**DEVIATION REQUEST  
AND DECISION FORM IN  
ASSOCIATION WITH A  
REQUEST FOR A PUD  
MODIFICATION FROM  
THE ECM**

A deviation from the standards of or in Section **ECM 2.3.8 .A** Engineering Criteria Manual (ECM) is requested.

Roadway Terminations	-Hammerhead turnarounds are not permitted as permanent roadway terminations.
----------------------	--

COVER

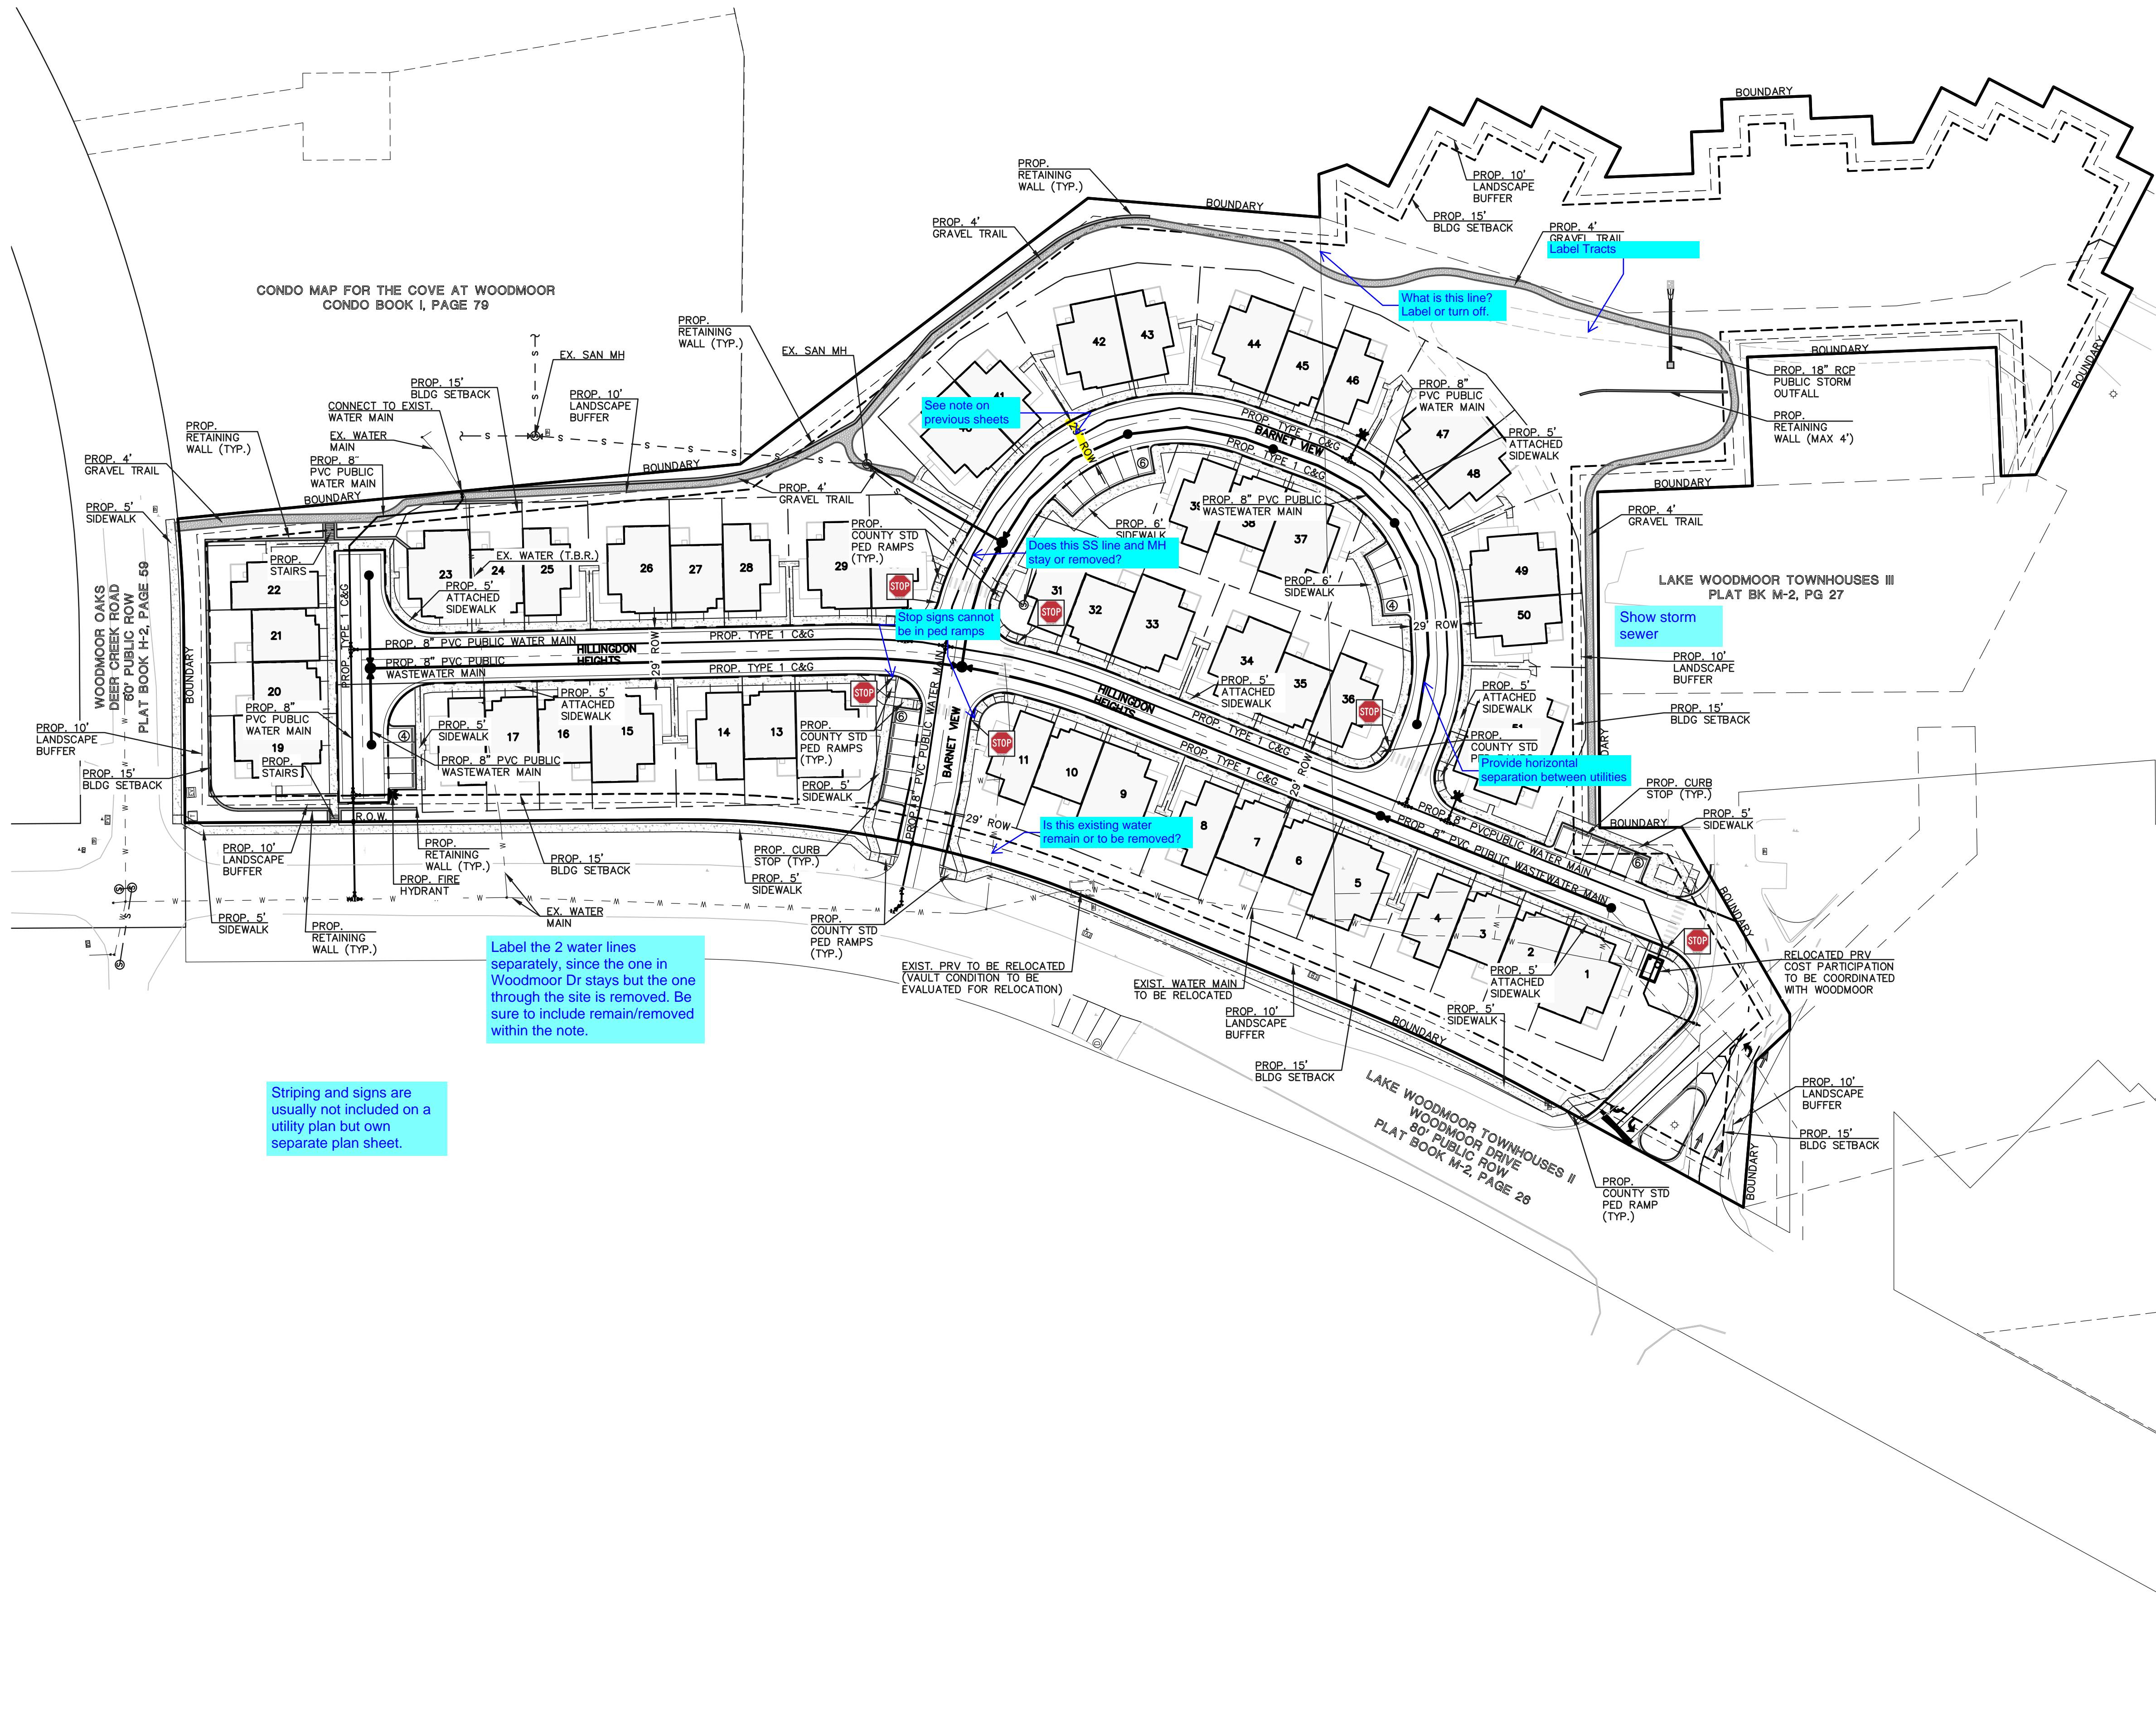
Provide exhibit to show roadway termination.

<p>The unique urban residential community consists of townhomes. While the main community access is from standard public local roadways, the use of the private roadways is limited to closed looped areas that will be signed as being private. Very short dead-end private roadways stubs are proposed (both under 80' in length) for two (2) locations throughout the community (northerly turnaround). Adequate emergency vehicle backing and maneuvering areas are provided.</p>	<p>Where is the second turnaround? Only see one on development plan.</p>
---	--

<p>The proposed short dead-end stubs (turn around) allow the continuations of the community design concept with no adverse impacts to resident maneuverability.</p>	<p>Explain how the hammerhead turnarounds will function in comparison to the allowed cul-de-sac turnarounds.</p>
---	--

Need further explanation as to why the usual cul-de-sac option is not viable.

Does not address aesthetics. How does it compare to the cul-de-sac turn around, as that is the criteria which is being deviated from.

This not address emergency access. This could impact emergency vehicles due to the hammerhead configuration being different than a cul-de-sac. Will need to provide letter that fire district is allowing the change.
